NORTH PENRITH DEFENCE SITE SUBDIVISION OF STAGE 3A (SSD 5348)

I am writing in reply to your request for comments on the Environmental Impact Assessment (EIS) for the North Penrith Defence Site Sub-division Stage 3A received by the Environment Protection Authority (EPA) on 10 September 2013.

ATTACHMENT A

Figure 4

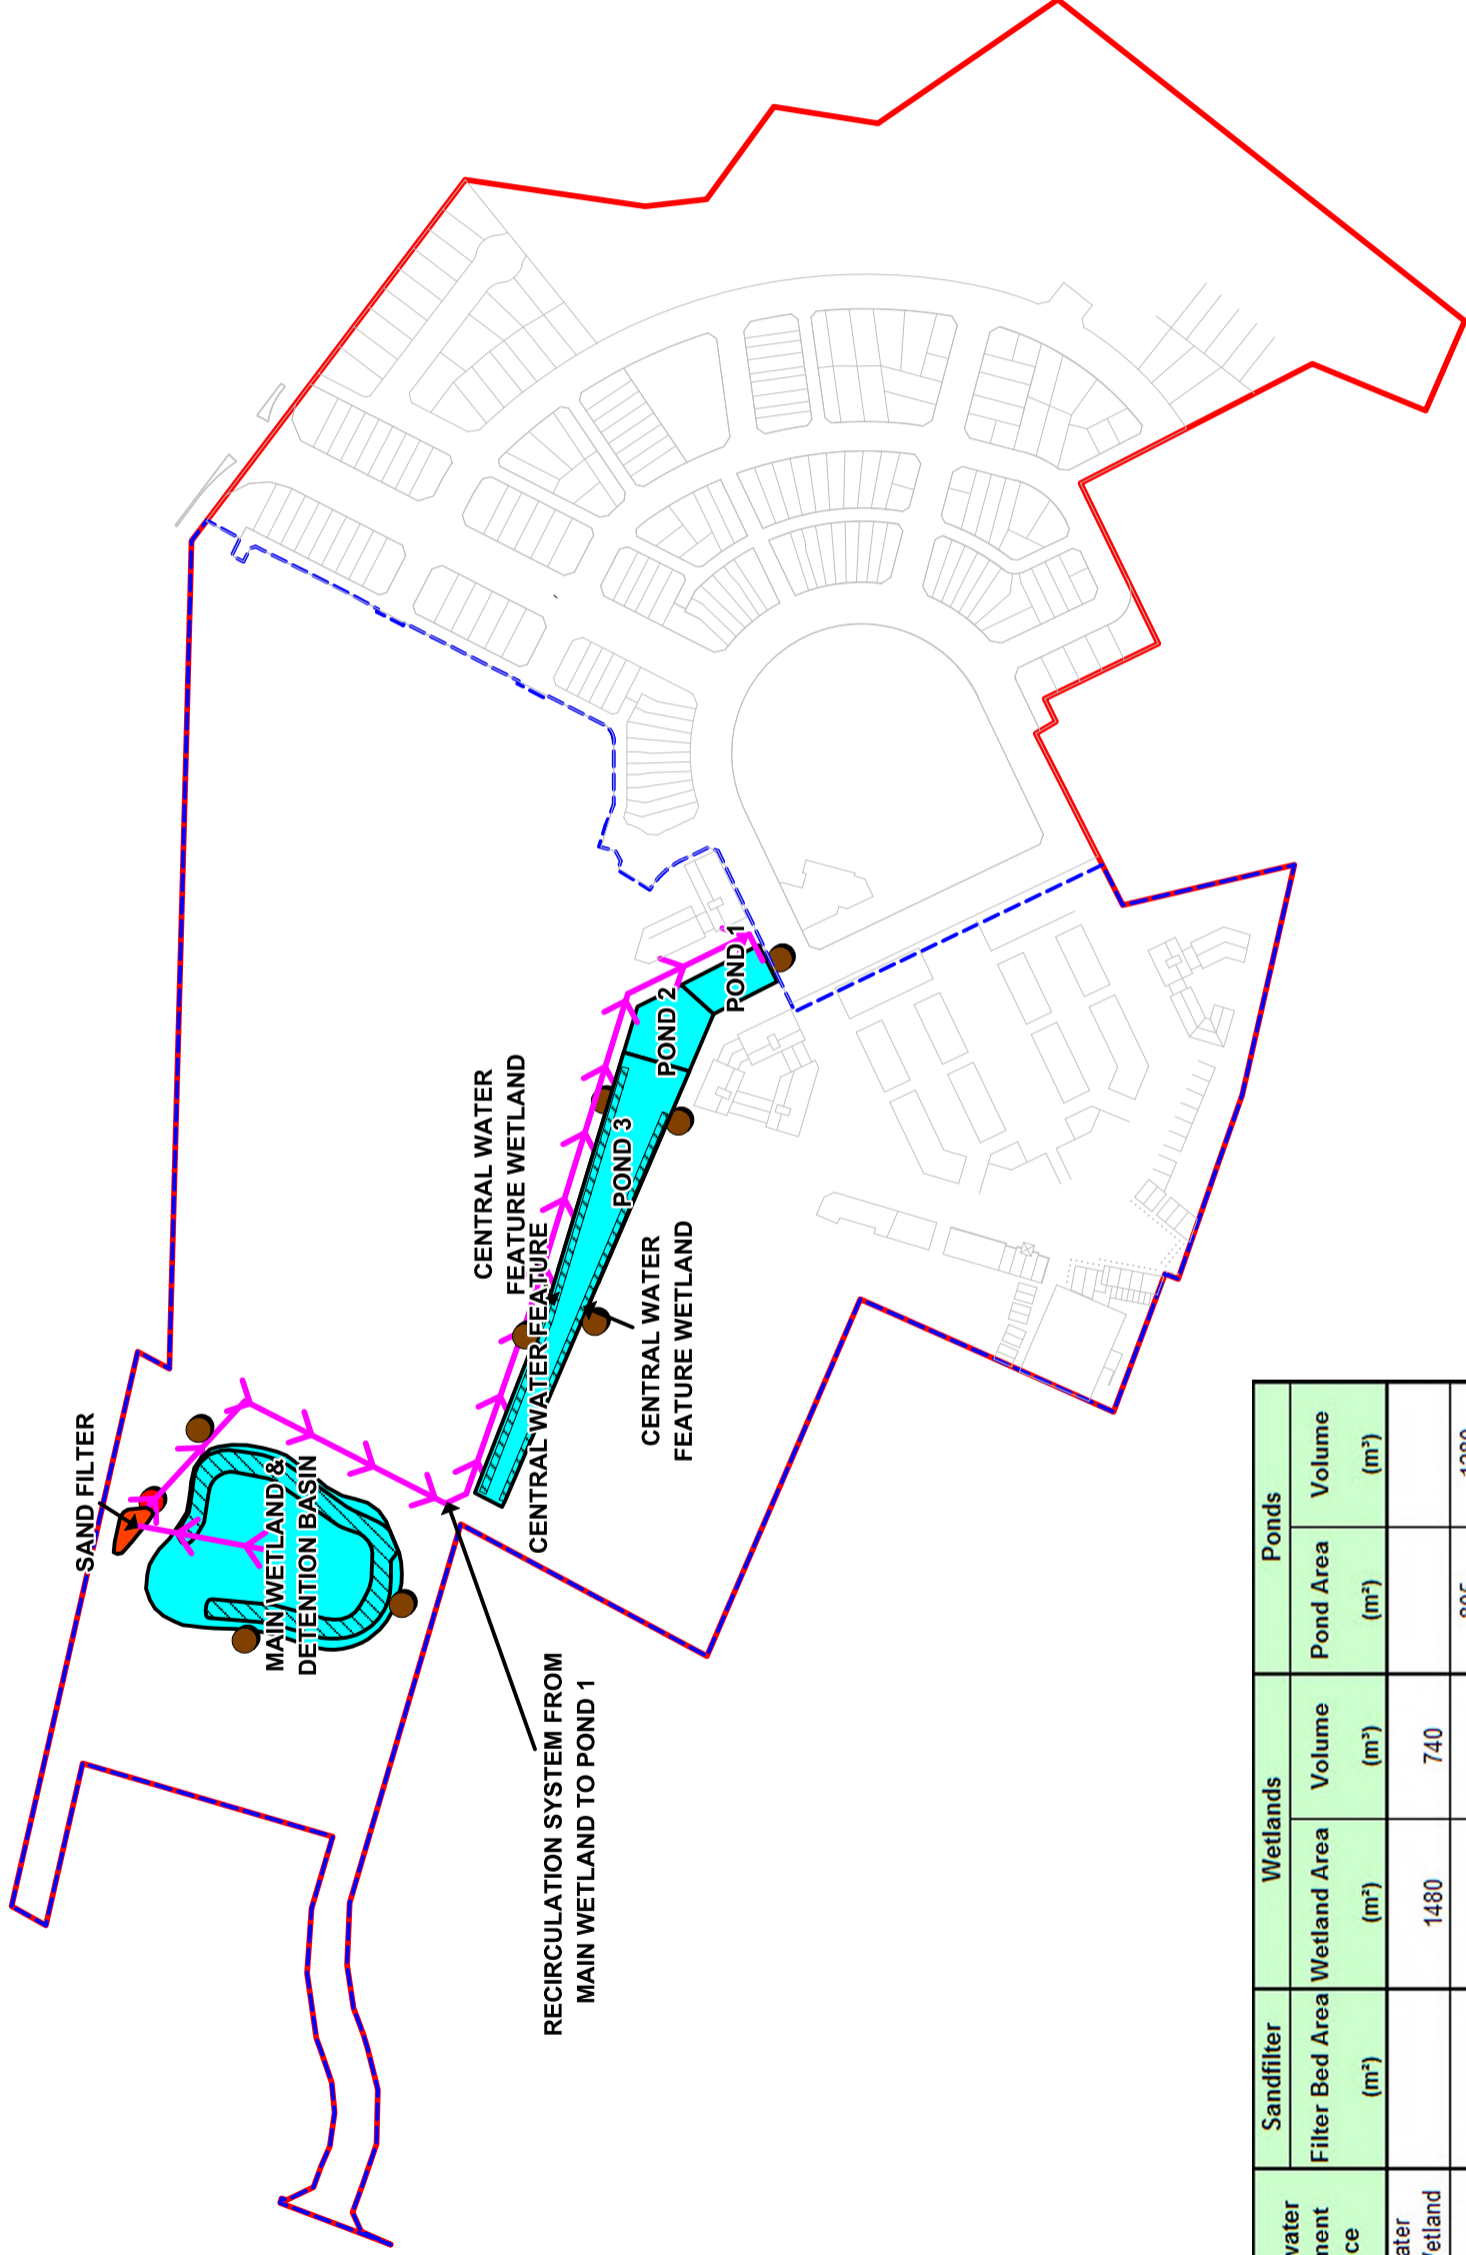
The Water Cycle Management Strategy consists of a stormwater treatment train comprising of on lot treatment, street level treatment and subdivision/development treatment measures in order to meet the OEH and Landcom water quality objectives for the North Penrith development. The EPA supports this approach, however the EPA recommends that a condition of approval be secured that requires the design and implementation of a monitoring program to ensure that the treatment train is performing as predicted to validate the water quality objectives are being met.

The success of the water cycle management strategy will be dependant upon ongoing maintenance. The EPA understands that the future management of the system will become a Council responsibility. In this regard, the EPA recommends that the proponent undertake a partnering arrangement with Council for a period of time post development to assist in transitional arrangements. This process will provide awareness training to Council staff in order to fully understand the systems performance and ongoing management responsibilities and maintenance needs.
